London Luton Airport Expansion

8.18 Statement of Common Ground between London Luton Airport Limited and Buckinghamshire Council (Tracked Change Version)

Application Document Ref: TR020001/APP/8.18

Deadline:	Deadline 3
Planning Inspectorate Scheme Reference:	TR020001
Document Reference:	TR020001/APP/8.18
Author:	Luton Rising

Figure 1 – Location of B488 / B489 Junction, Ivinghoe

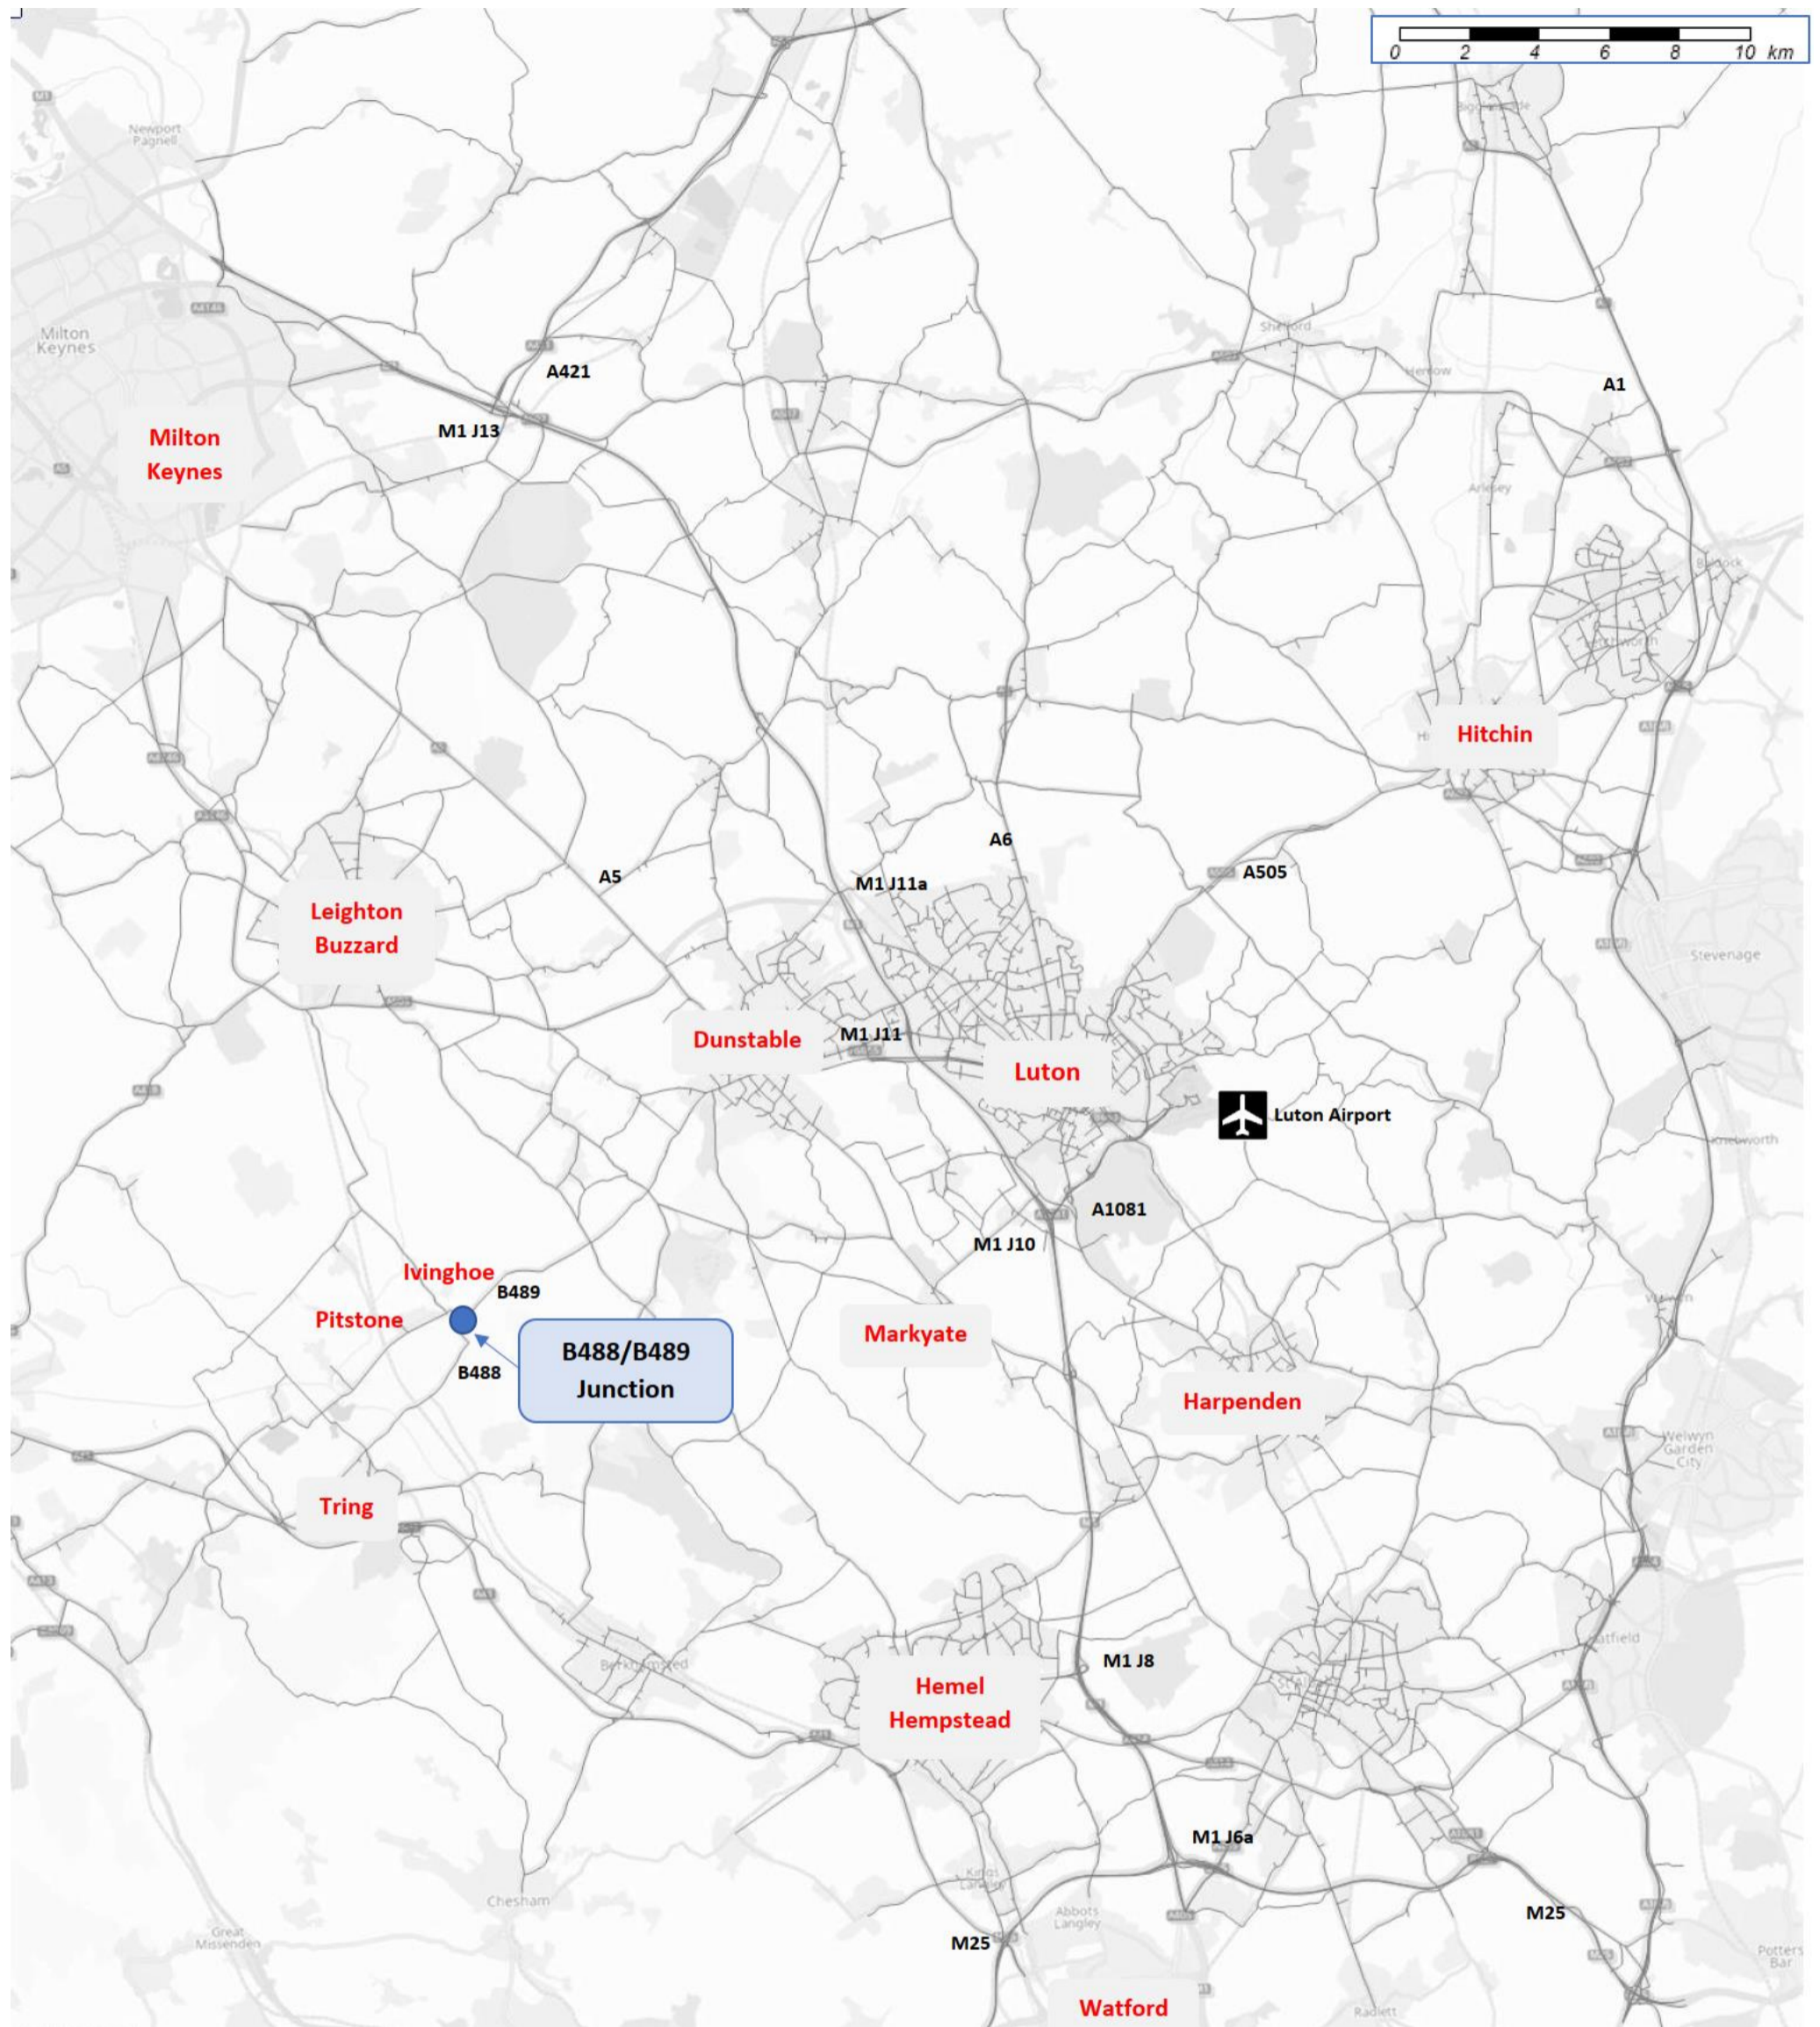
3.3.2	Highway mitigation works	<p>BC seeks agreement from the Applicant for highway mitigation works at the junction of the B488 and B489 in Ivinghoe to change the junction priority, as required by Policy TRA2 of the 'made' Ivinghoe Parish Neighbourhood Plan 2014-2033. It is acknowledged that the projected peak hour traffic in this area is expected to be low, but the Council considers that this is a major route from Buckinghamshire and Dacorum to the Airport, and the sensitivity of the network in this area is such that small changes would have</p>	<p>This junction was not identified as requiring mitigation following a comprehensive Transport Assessment. Any proposed mitigation at this junction is the responsibility of the local highway authority.</p> <p>The Applicant will continue to engage with BC on this matter.</p>		Ongoing
